**RE: BLESSED CARLO COLLEGE MOAMA
BCA AND DDA COMPLIANCE STATEMENT FOR DA SUBMISSION**

This statement has been prepared to verify that Blackett Maguire + Goldsmith Pty Ltd have undertaken a review of the architectural documentation that will accompany the Development Application submission to Murray River Council for the proposed development works comprising of a new primary and secondary Catholic school at the subject site against the Building Code of Australia 2019 Amendment 1 (BCA 2019 Amendment 1), and DDA provisions of the Premises Standards.

Drawing No.
210026/DA130

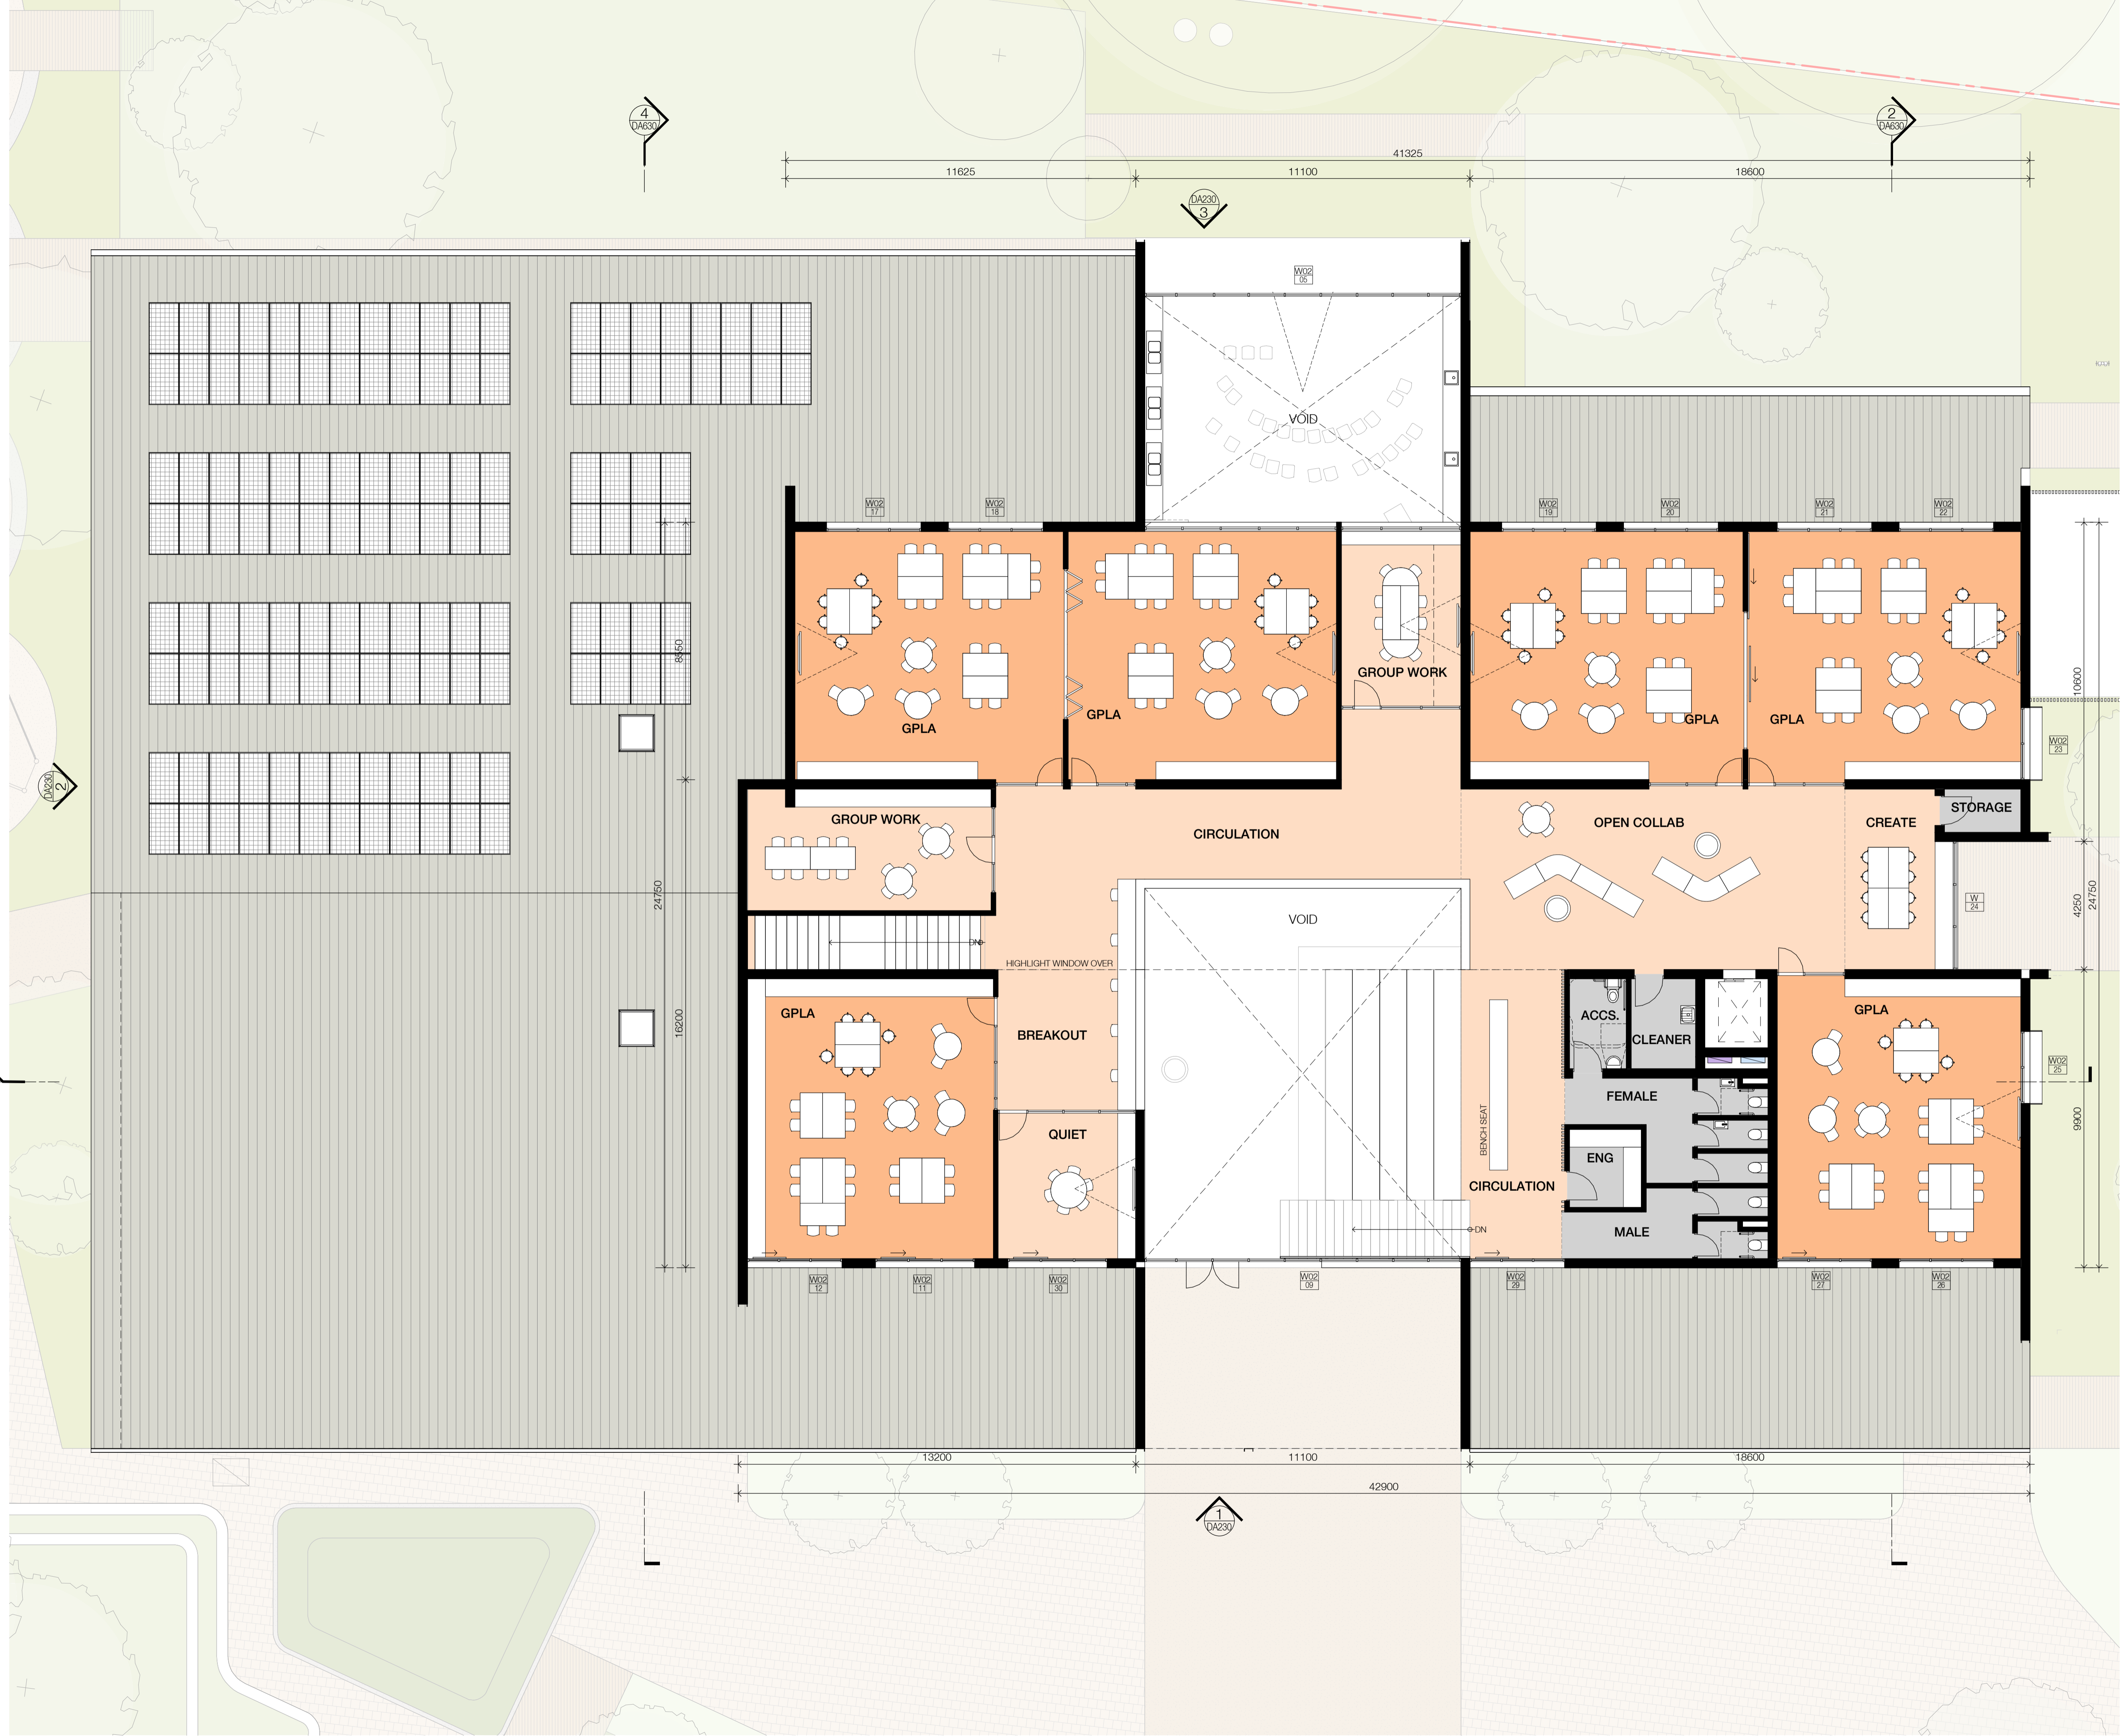
BUILDING D – WORKSHOP & SENIOR SCHOOL	12m separation to Building D From the western side of Building D where the external wall is between 9m-18m from Building C, the external wall is required to achieve an FRL of 120/30/- if it is <u>loadbearing</u> . <i>Structural Engineer is required to confirm what elements of Building D will be loadbearing.</i>
--	---

1 Section 1
 DA130 Scale 1 : 100

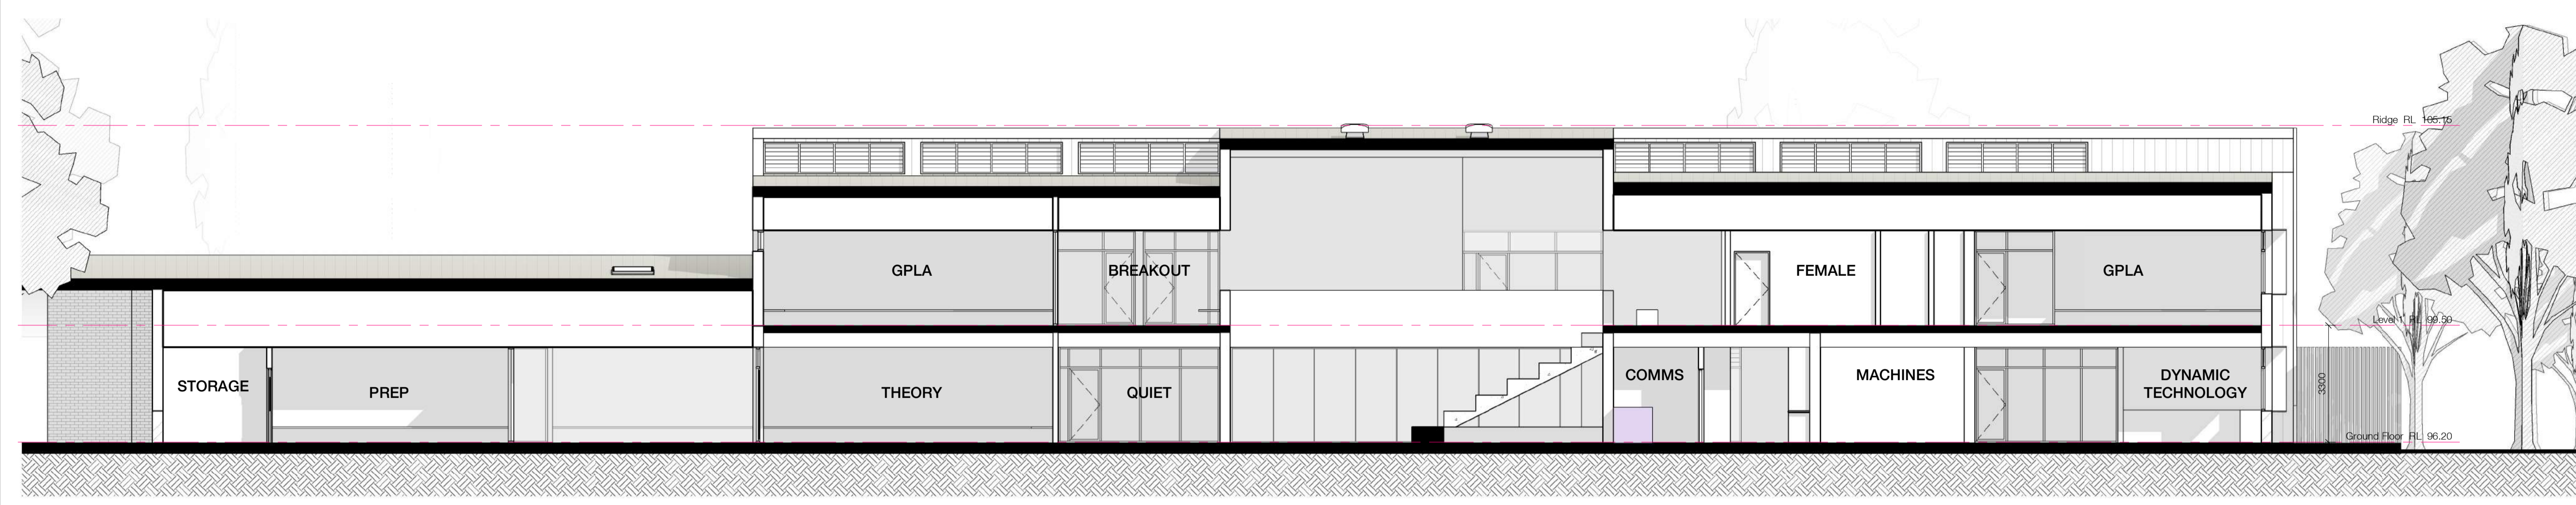
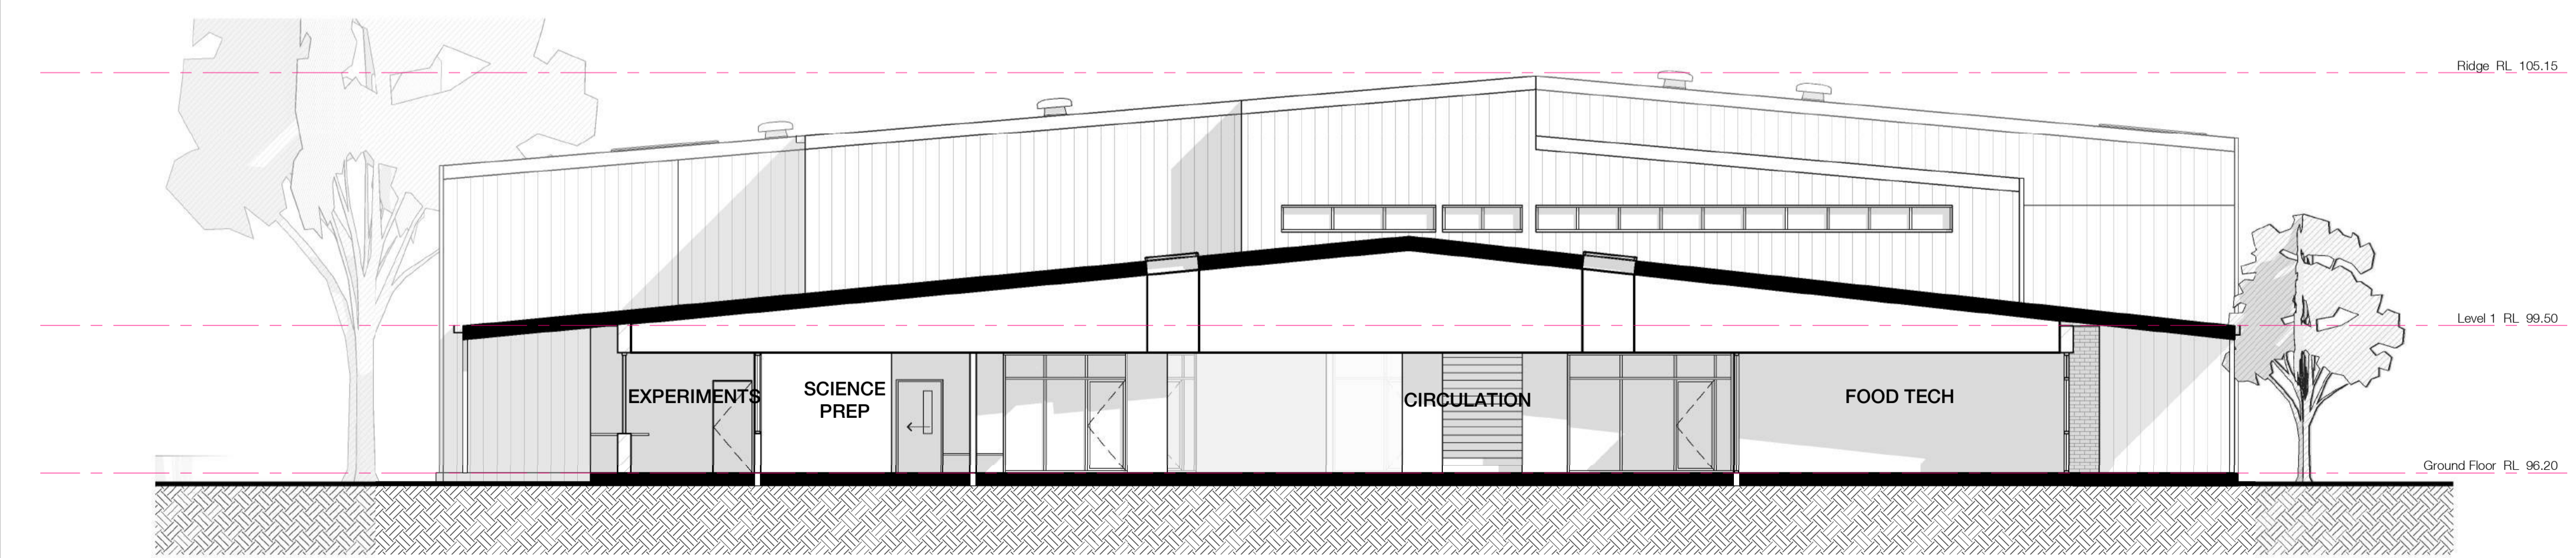
These requirements apply to the tiered seating in the secondary school. Provide a section in accordance with the above requirements.

A key requirement is the bottom treads must be outside of the bottom platform and not set-in.
